WEST SUSSEX COUNTY COUNCIL CONSULTATION

TO:	Arun District Council FAO: Ms M Tomalova
FROM:	WSCC - Highways Authority
DATE:	28 January 2020
LOCATION:	107 Felpham Way, Bognor Regis, PO22 8QB
SUBJECT:	FP/258/19/PL Conversion, alteration & extension to provide 1 No. Class A1 Shop Unit, 1 No. Flexible Use Commercial Unit Use Classes A1/A2/B1/B8/D1 or Sui-Generis Beauty Therapist/Nail Bar & 3 No. Flats together with 3 No. vehicle parking spaces & secure cycle & refuse storage facilities (resubmission following FP/32/19/PL).
RECOMMENDATION:	Modification

2019-6108-002

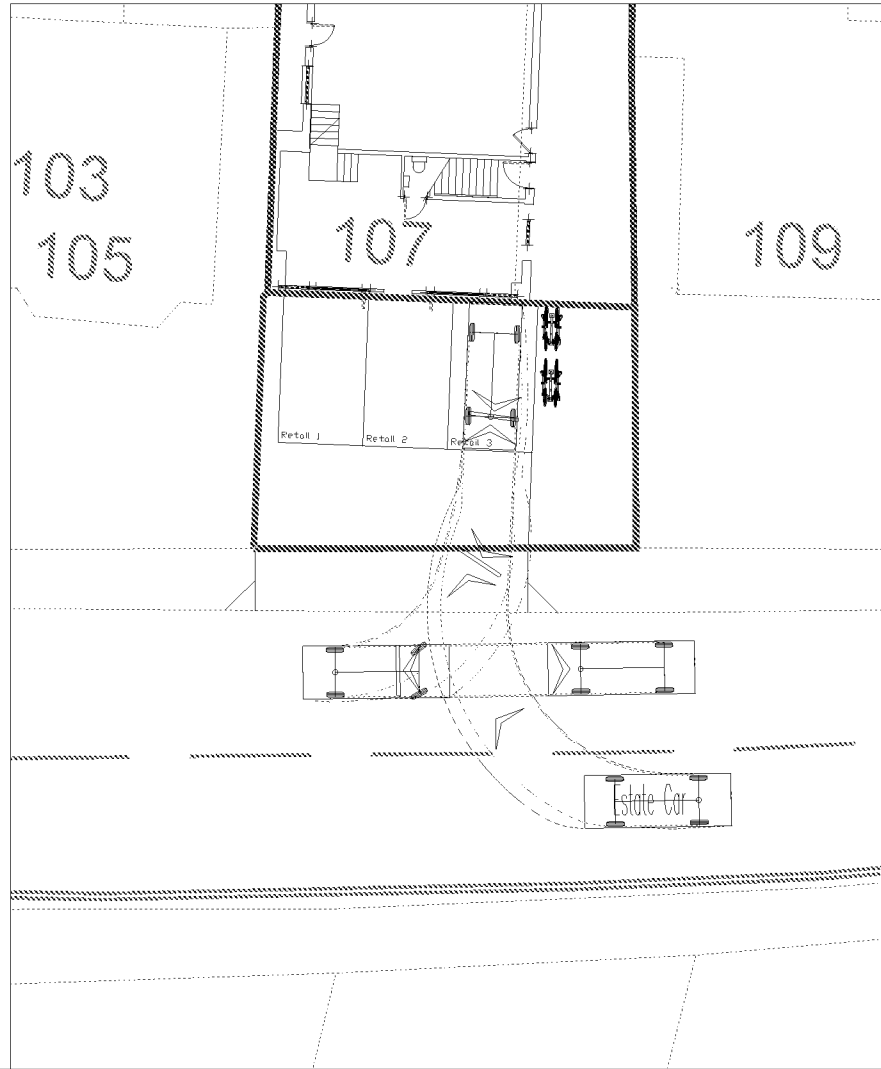
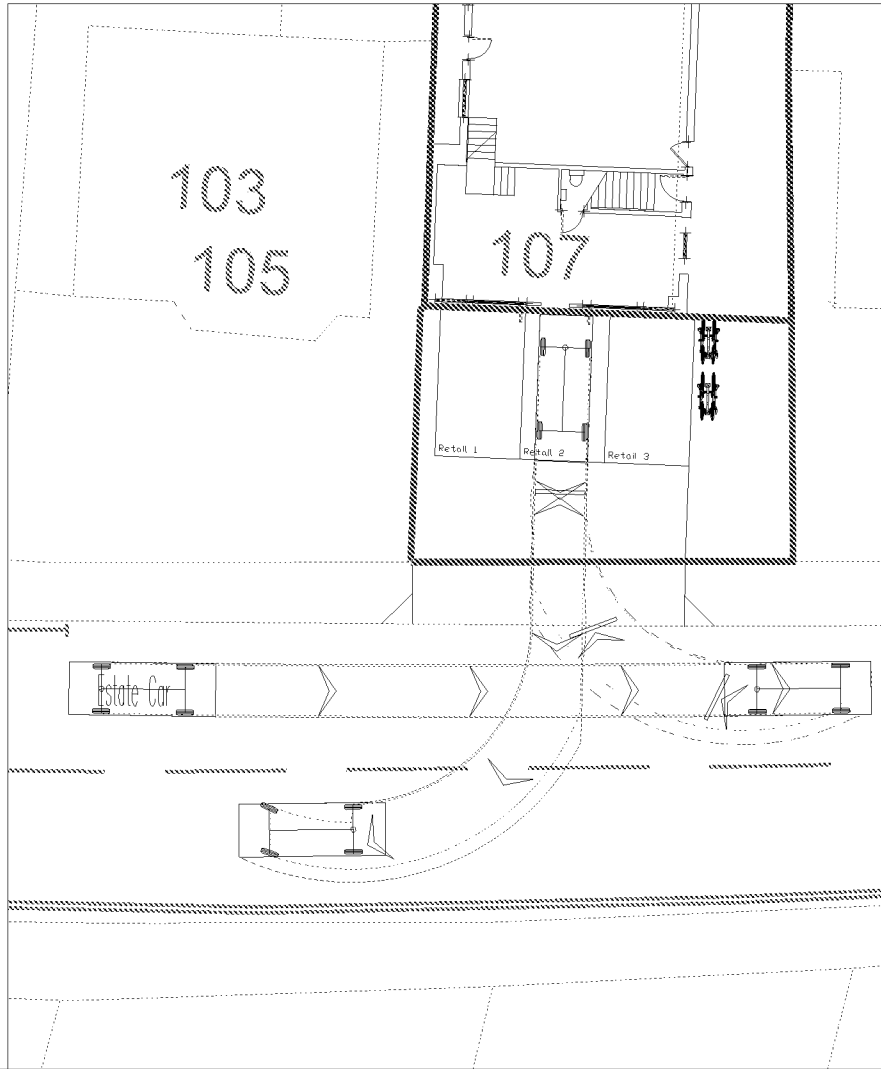
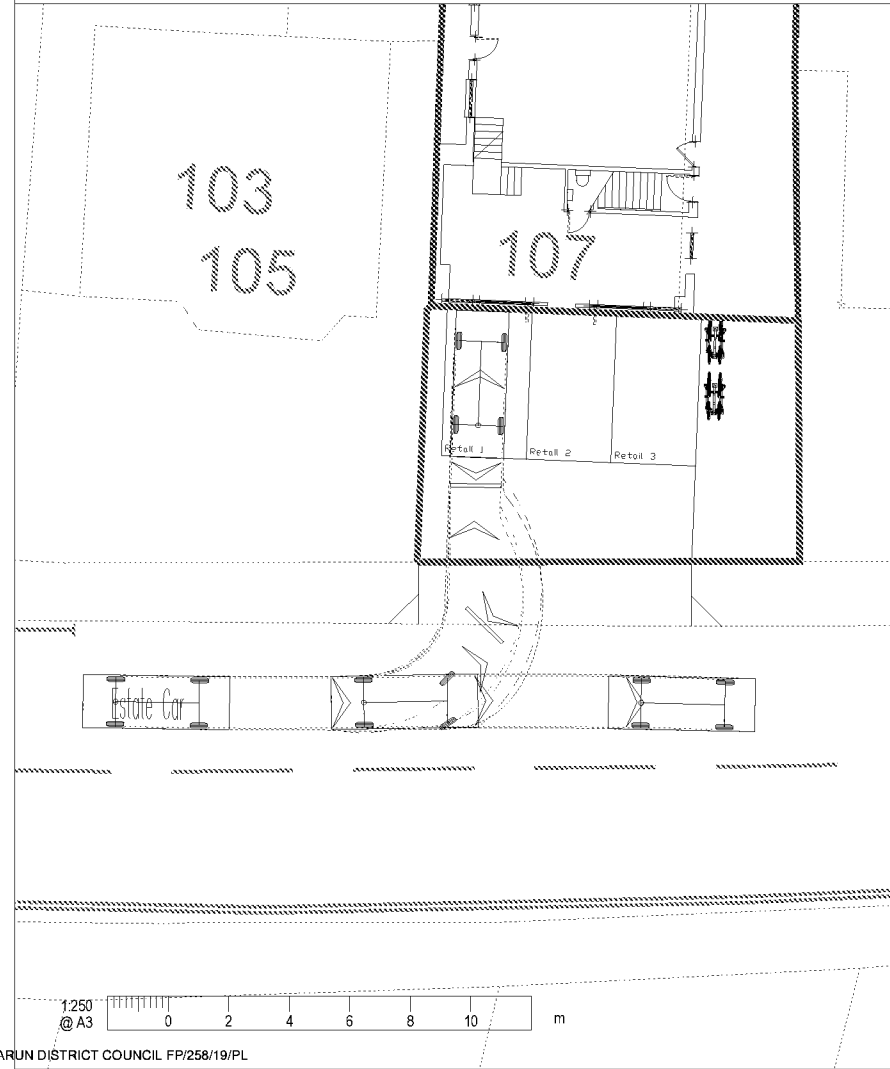
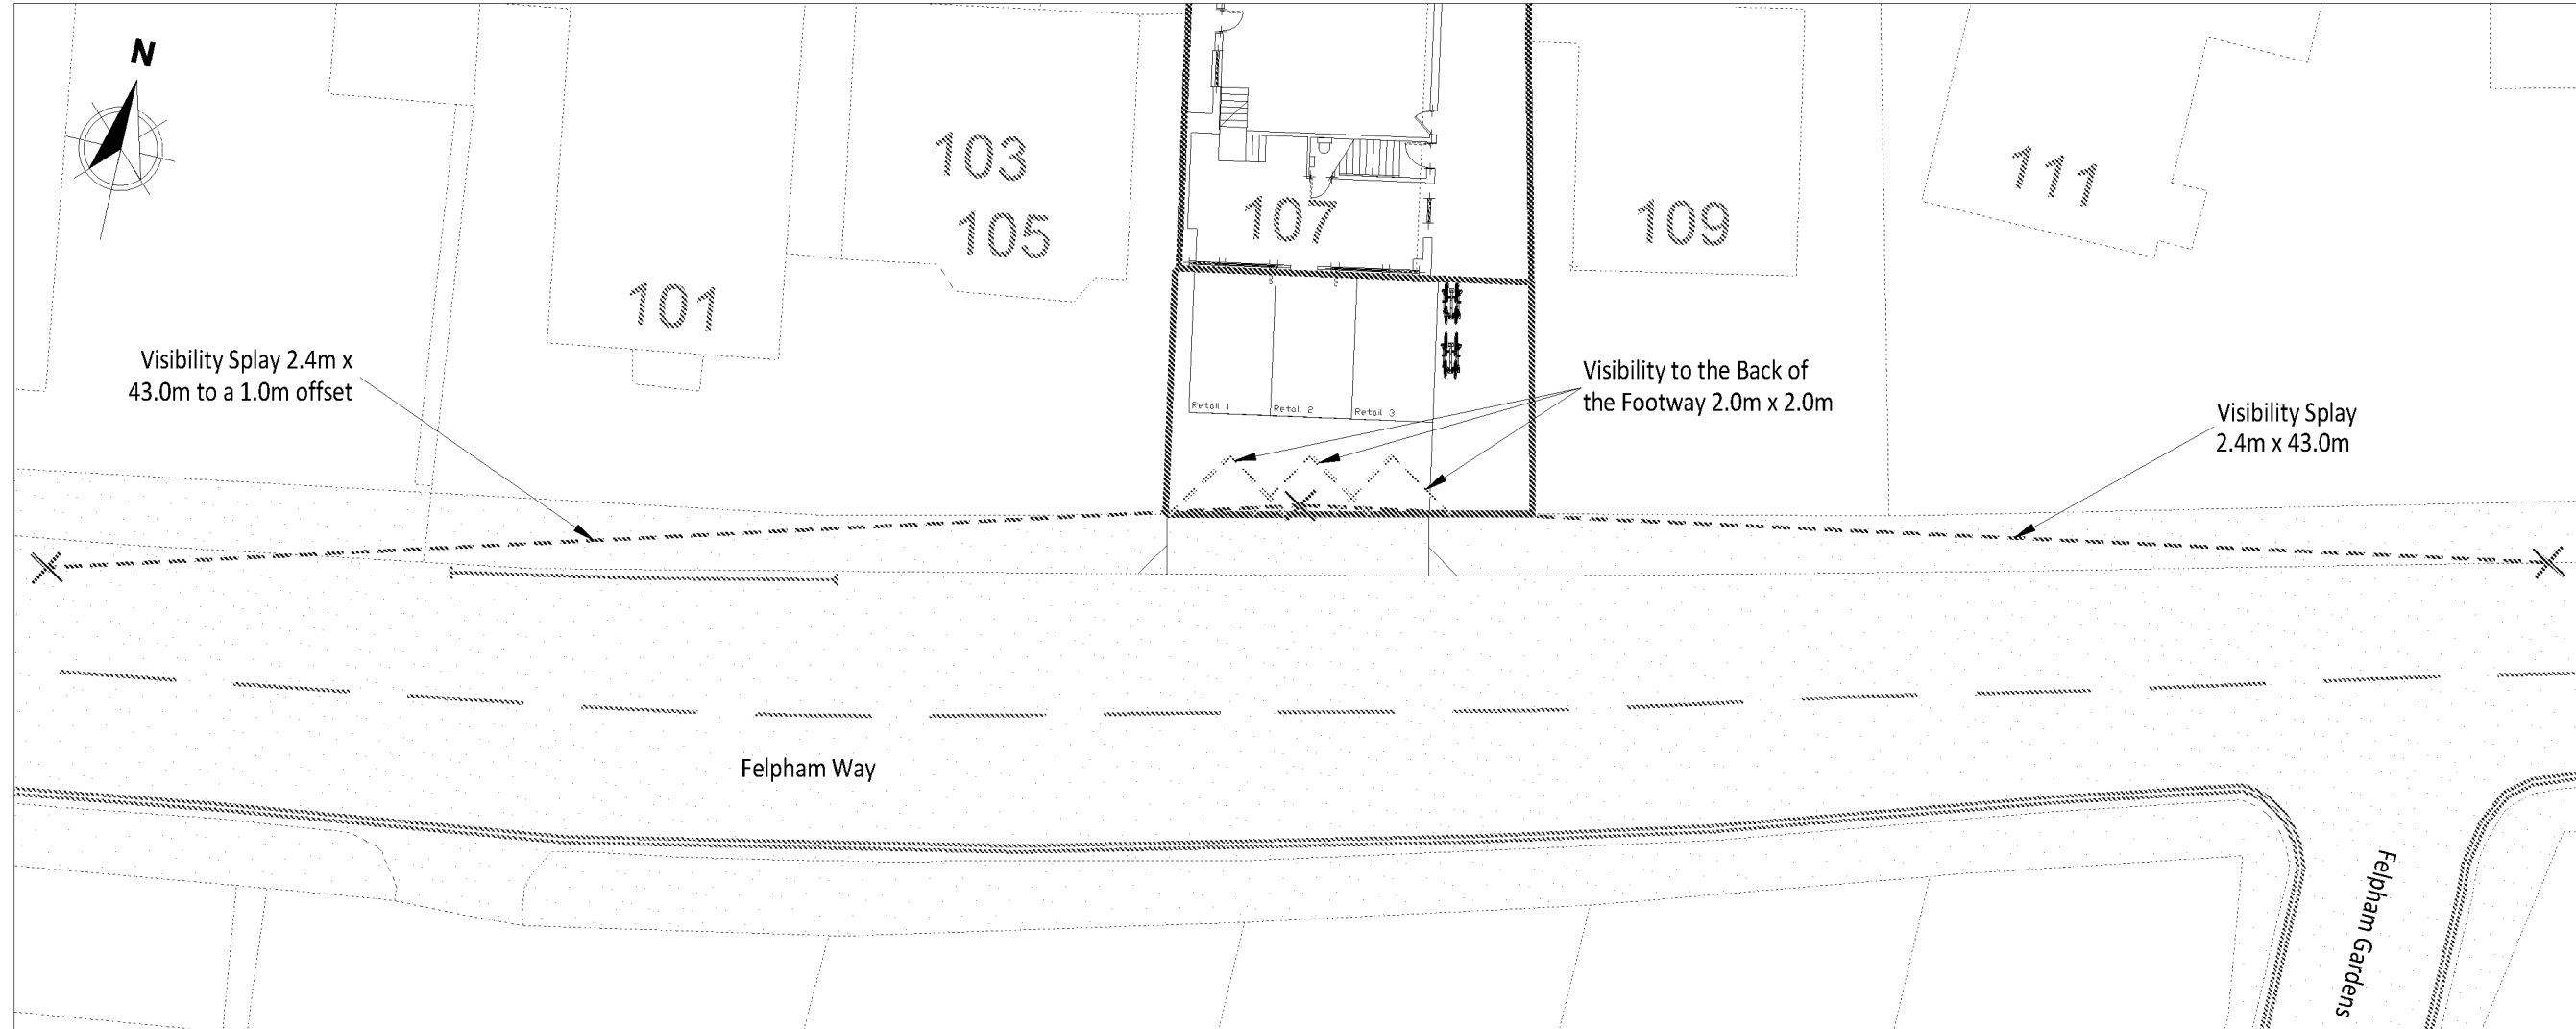
The plans state that the existing kerb is already dropped however the TS states that a 9 metre vehicle crossover (VCO) is proposed (extension to existing 4 metre VCO). An inspection of local mapping indicates that this is the case and the existing dropped kerb would need to be extended across the site frontage to facilitate access to the proposed car parking spaces.

Swept path tracking diagrams within the TS demonstrate that a car can independently access each space. Nevertheless, the position of the parking spaces appears to block access to the A1 unit. The spaces should be repositioned and applicant should consider whether space fronting existing dropped kerb could also be used.

In summary the principle of development is not anticipated to result in a highway safety or capacity issue, however the LHA require that the parking space locations are modified to make best use of the forecourt area and not block access to the units. The location and amount of bicycle parking should also be reviewed.

Ground Floor Plan - Proposed 1:100

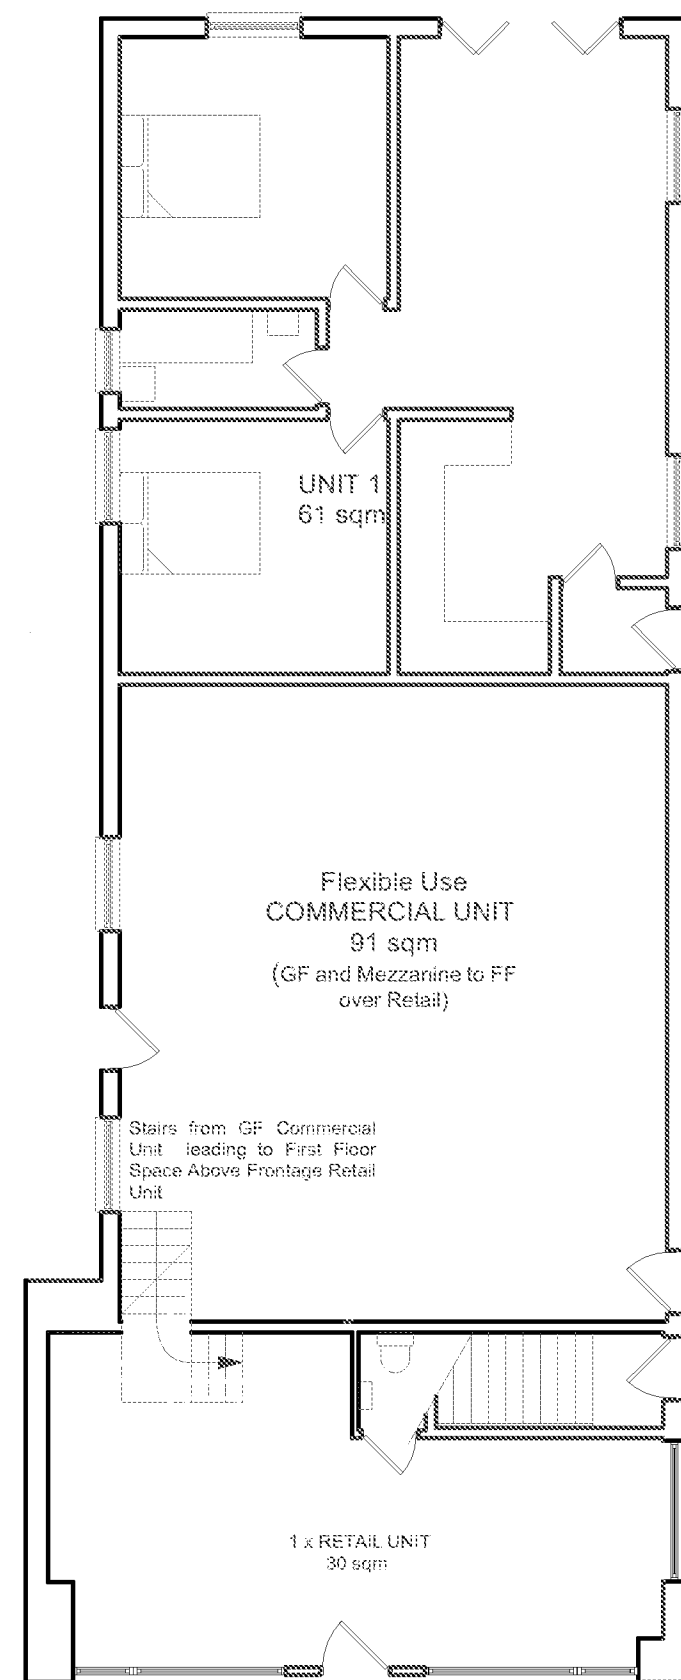
on A1 use only which would result in a requirement for 2 x spaces (both customer and staff). A bicycle store facility has been indicated on the frontage. The applicant may wish to consider relocating this, depending on how the car parking spaces are reoriented and space available for access.
